Application for a non-material amendment following a grant of planning permission.

Number	
Suffix	
Property name	43-45
Address line 1	Reservoir Road
Address line 2	Surfleet
Address line 3	
Town/city	Spalding
Postcode	PE11 4DH
Description of site location must be completed if postcode is not known:	
Easting (x)	527840
Northing (y)	329263
Description

Residential development - three dwellings with associated parking and amenity space - outline approval H17-1149-18	
Reference number:	H17-0423-19
Date of decision	10/06/2019

Drawing No:EBD-004 43 Reservoir Road Surfleet Second NMA Drawings Rev C

Detached Proposed Ground Floor Plans
Scale 1:50 @ A1

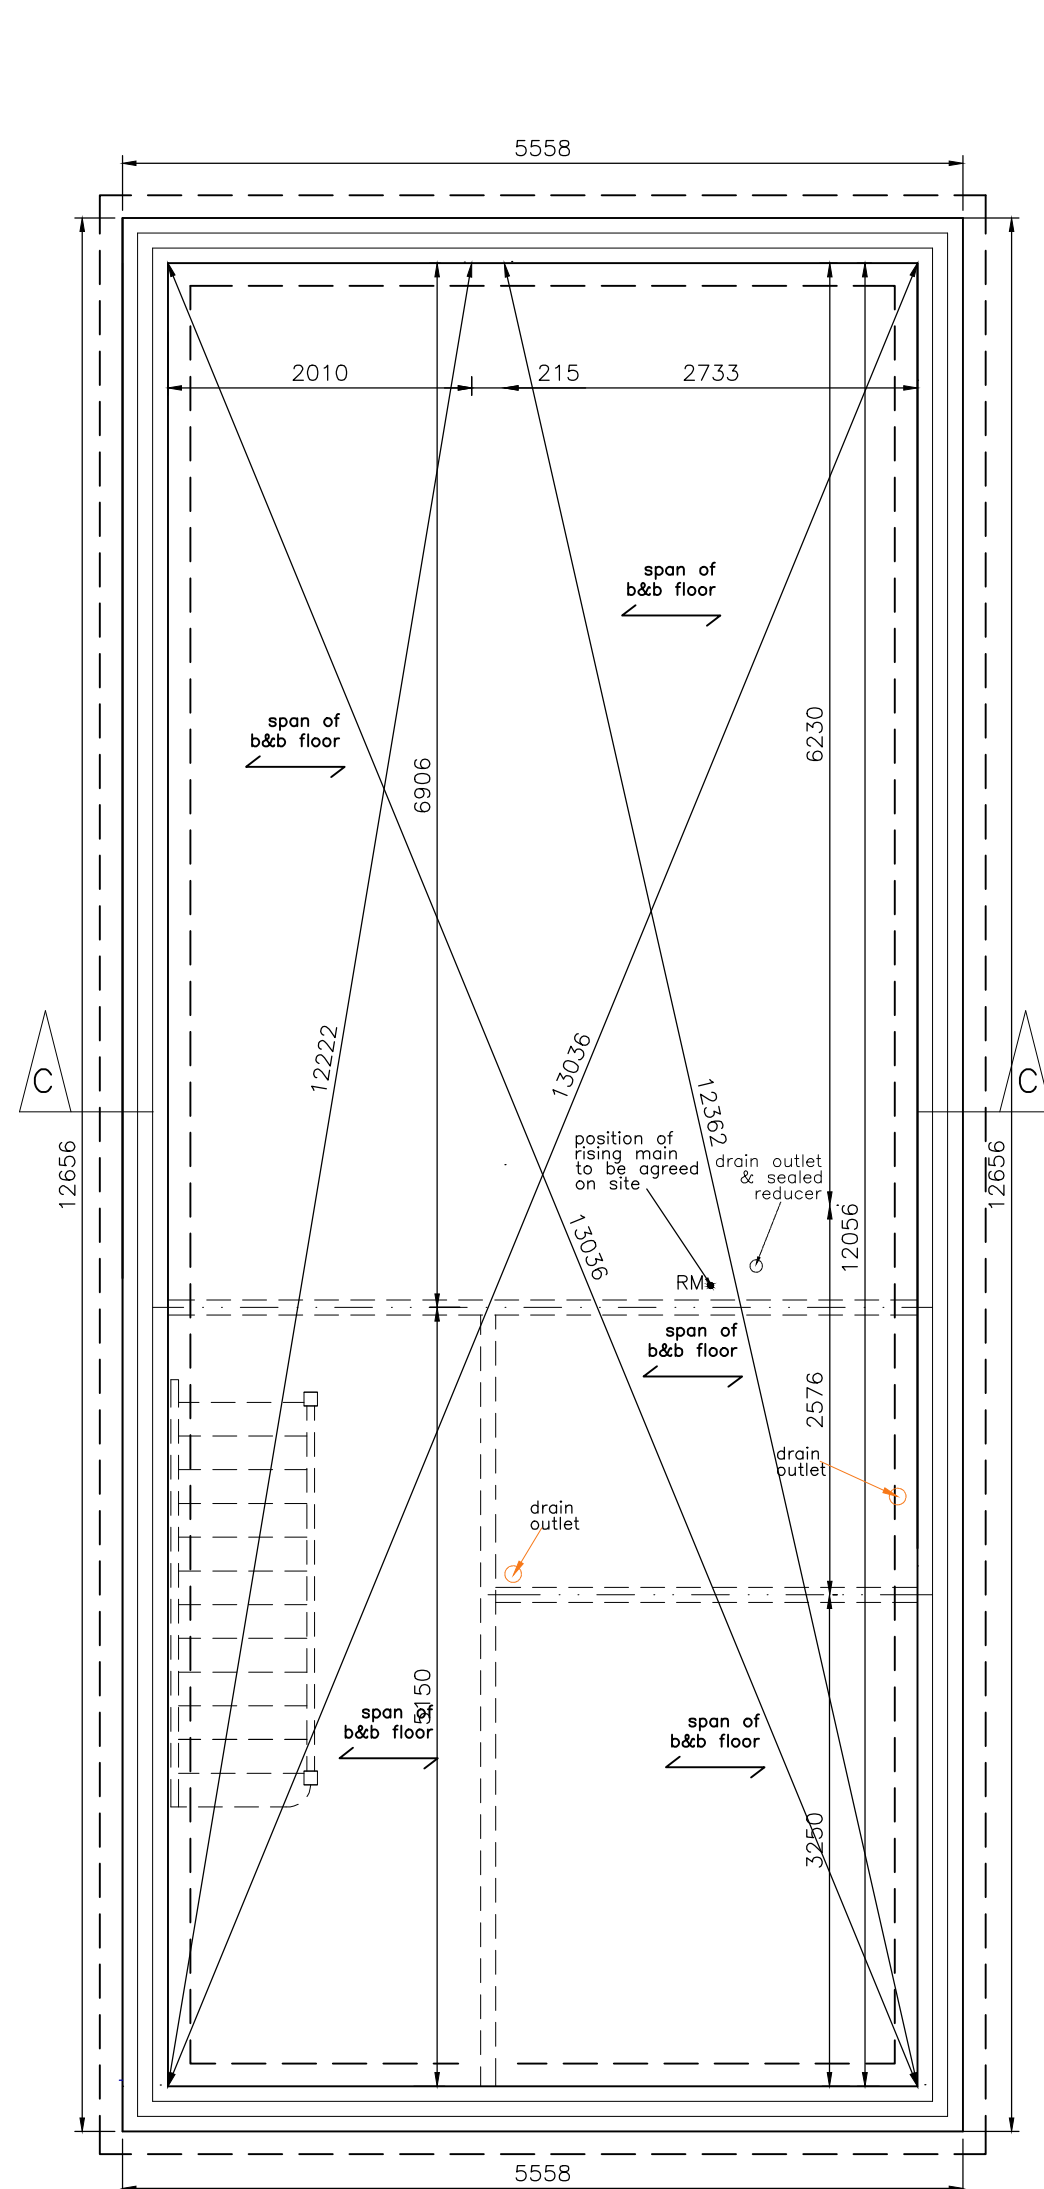
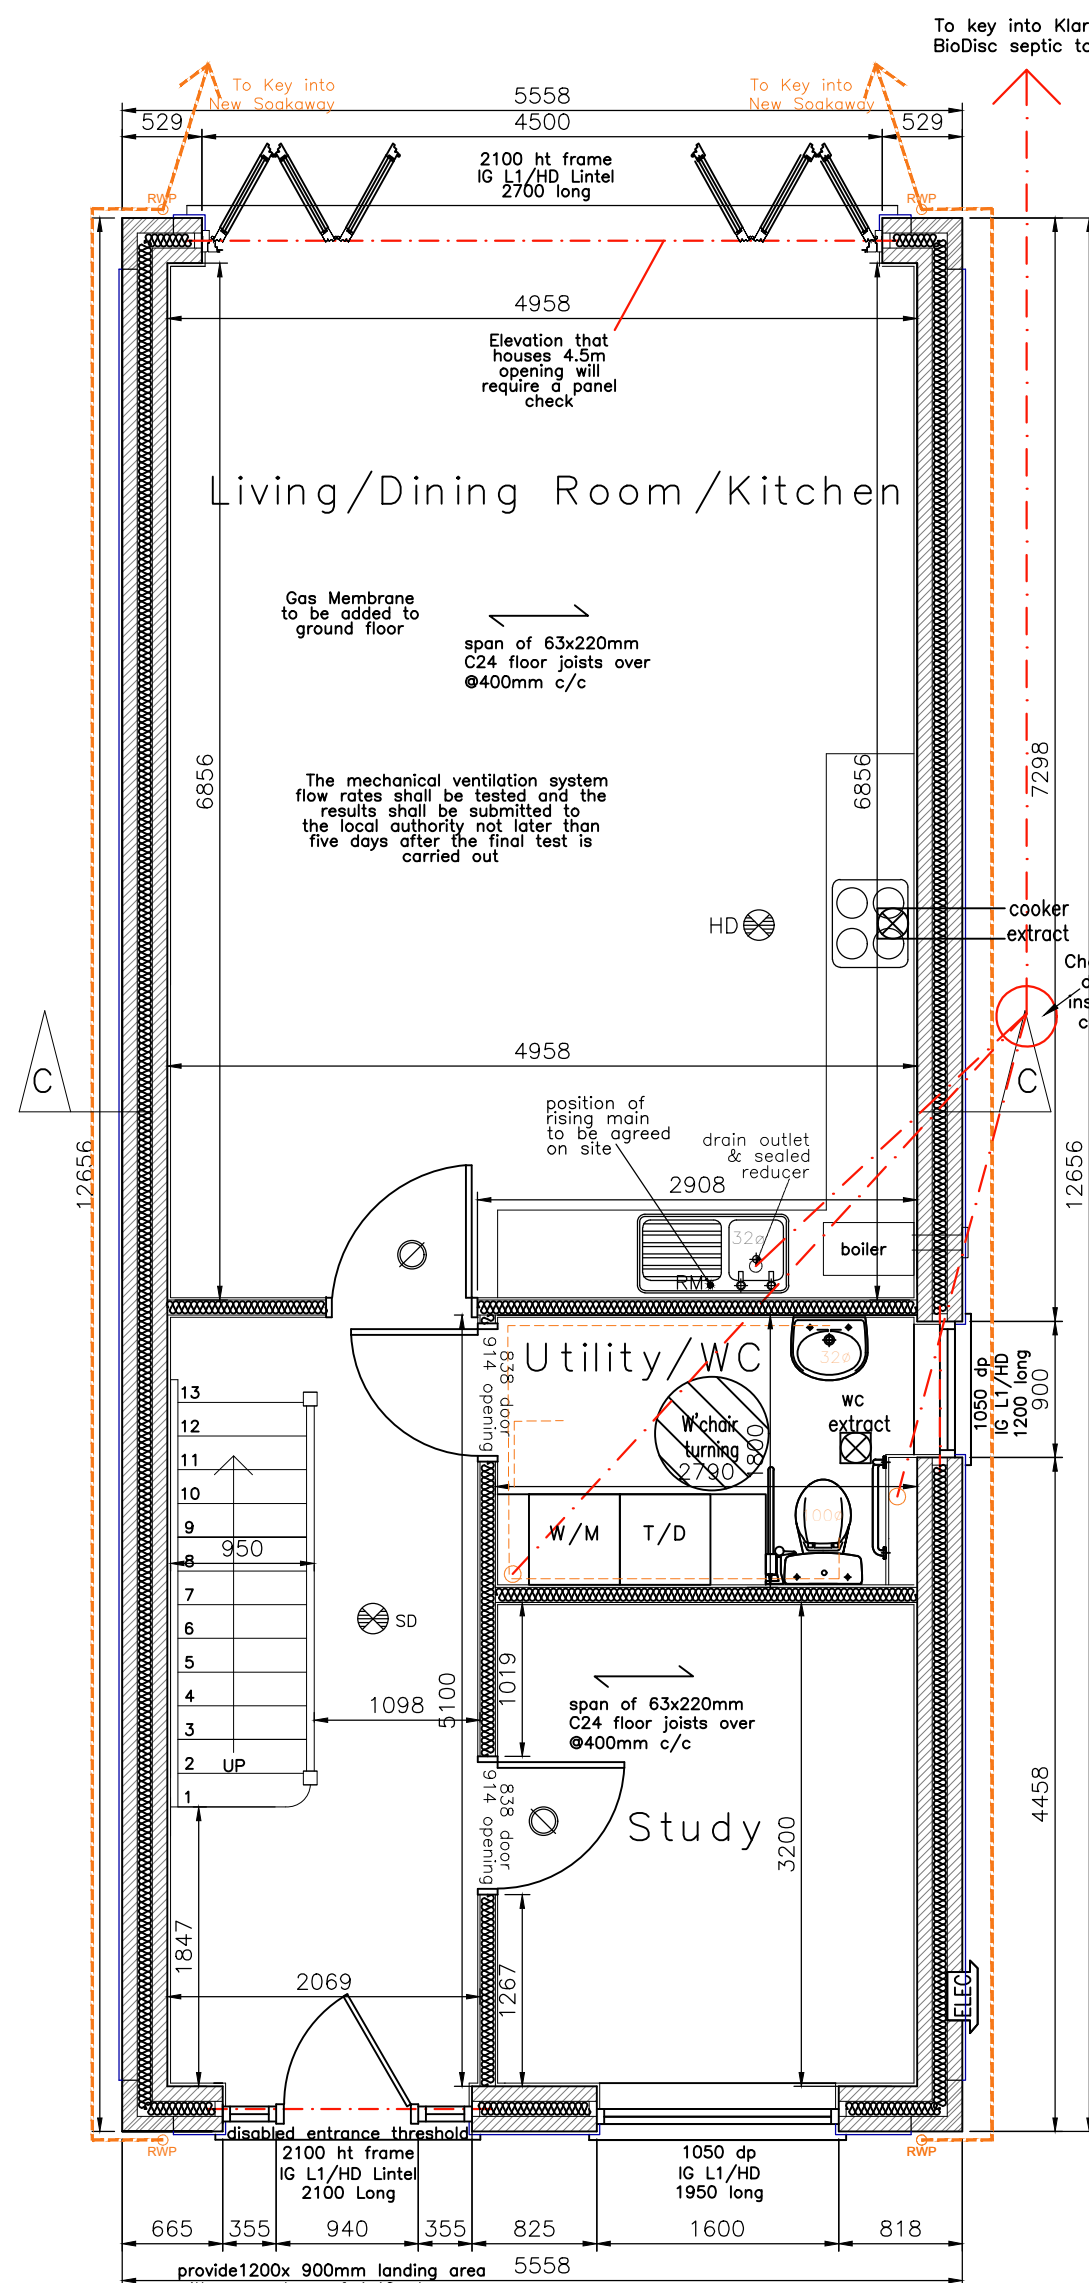
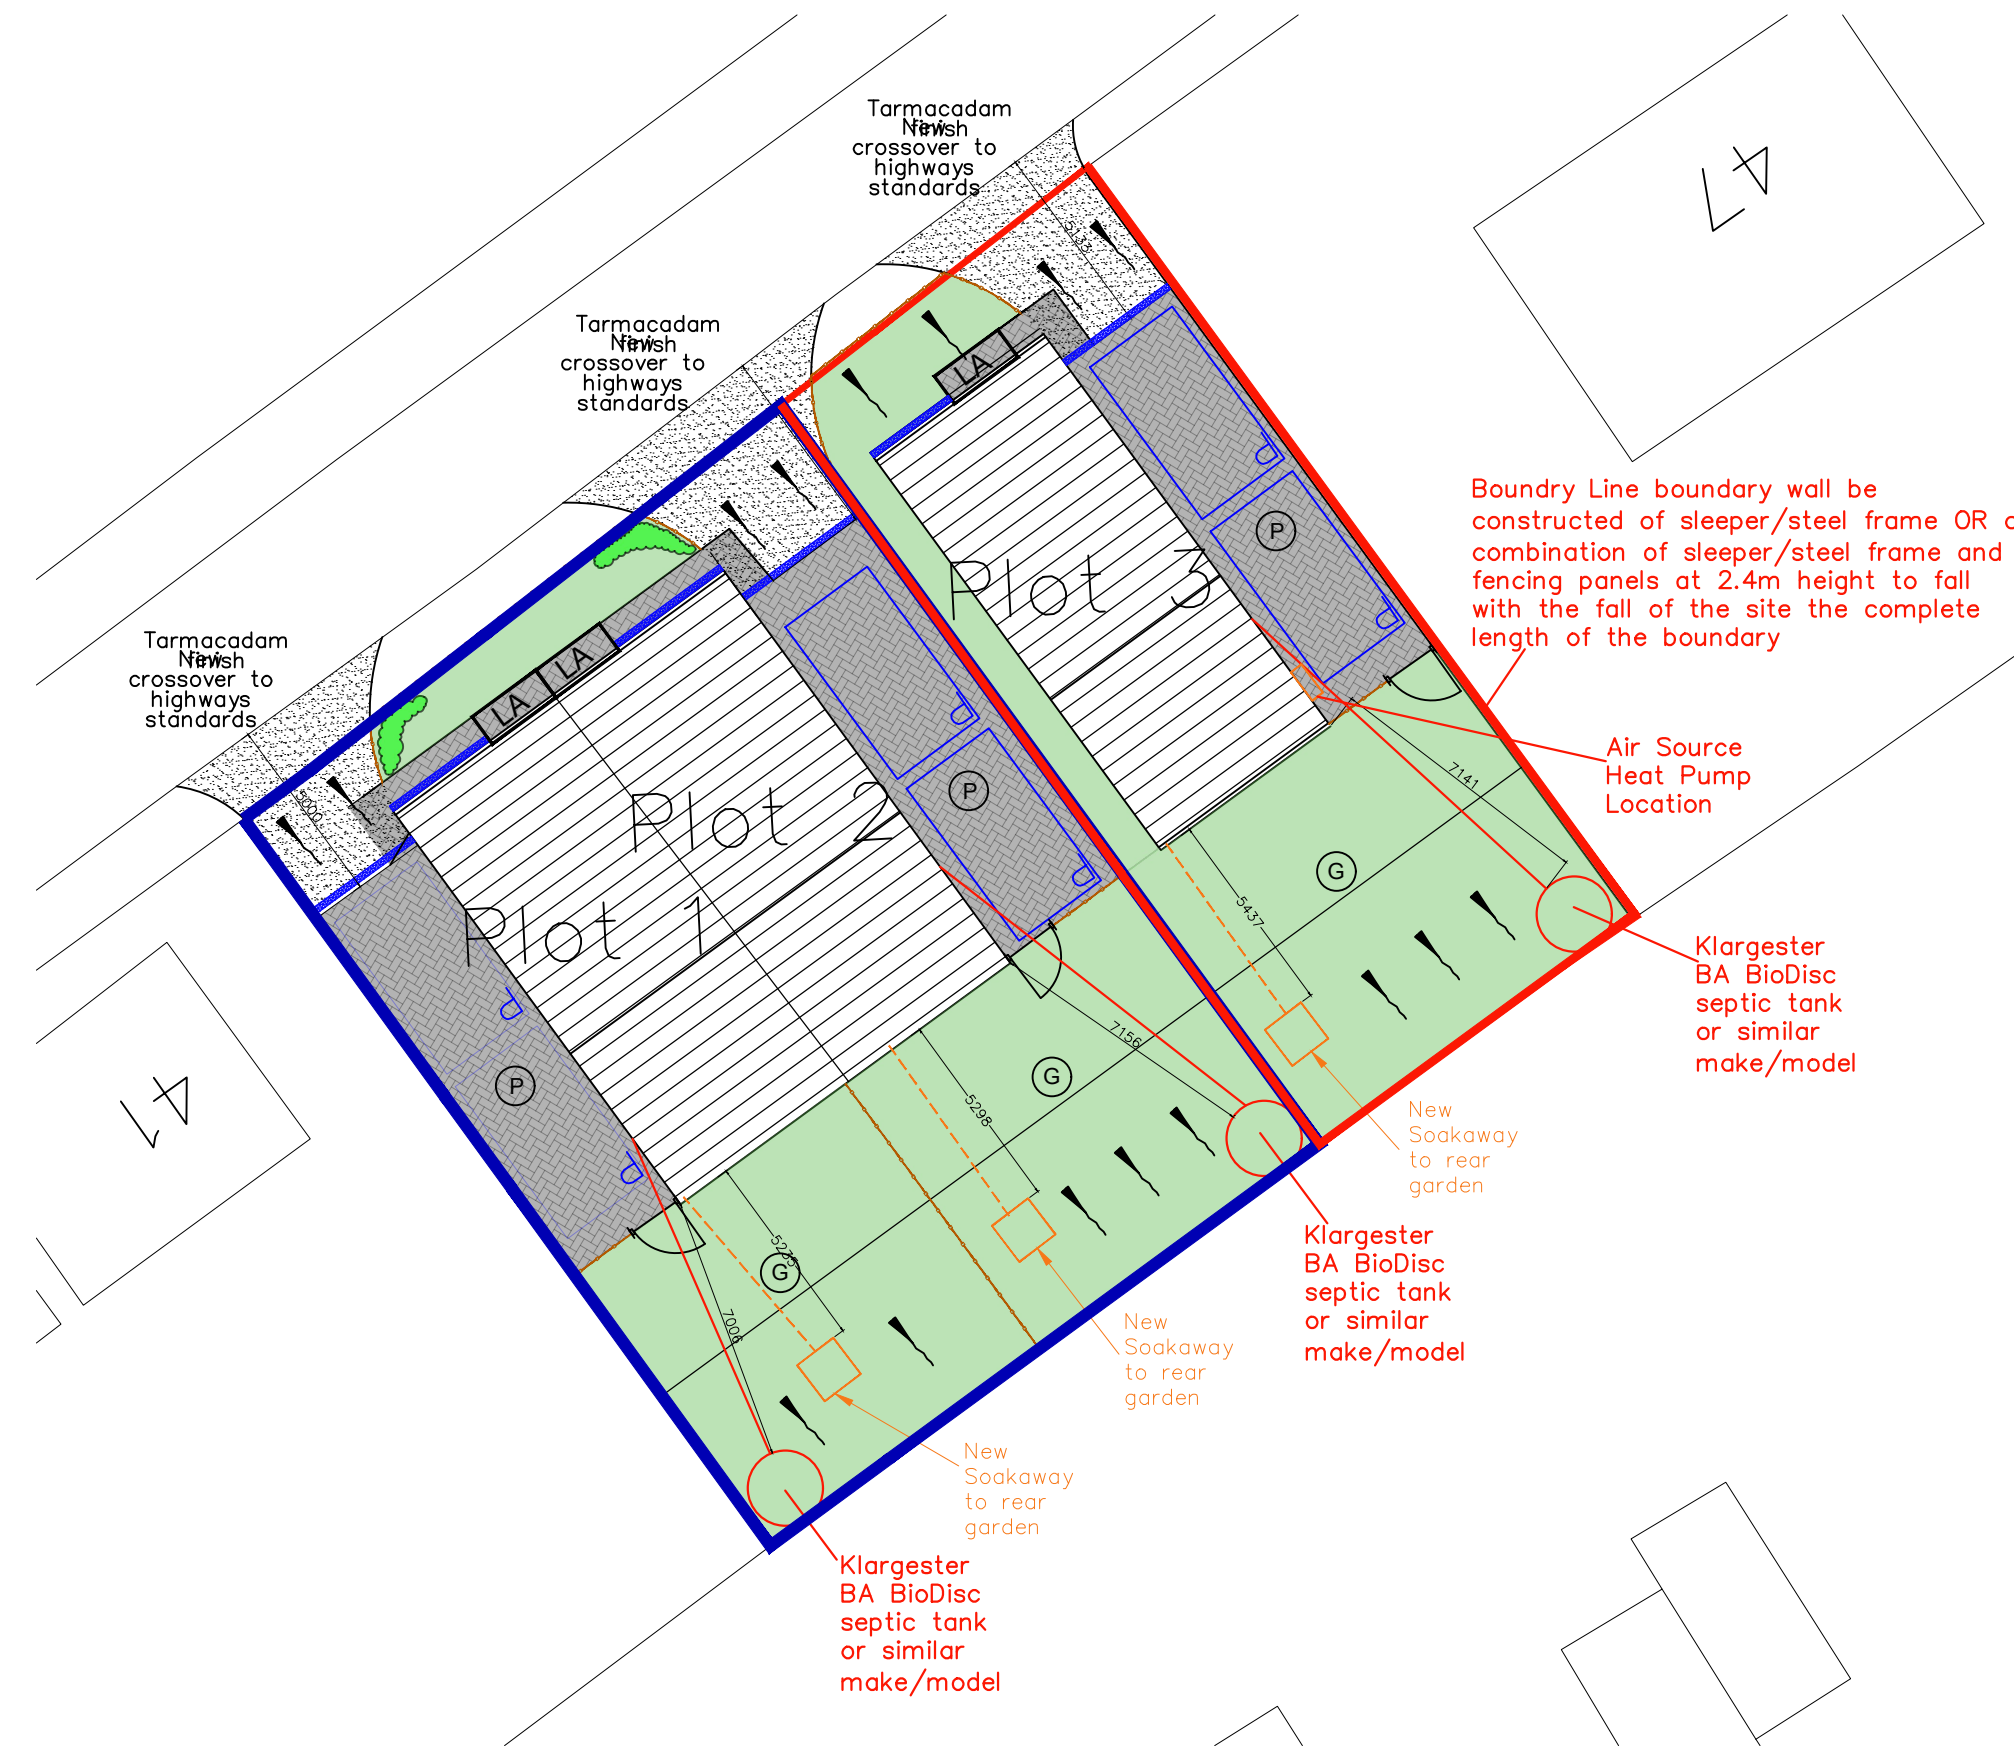
Internal amendments to layout of ground and first floor, front entrance door to change from a double door to a single door with side windows. Window and door finished changed from white uPVC to black uPVC. PVC u beading render. Position of air source heat pump indicated and roof light to flat roof dormer changed to a flat velux type from dome shaped.
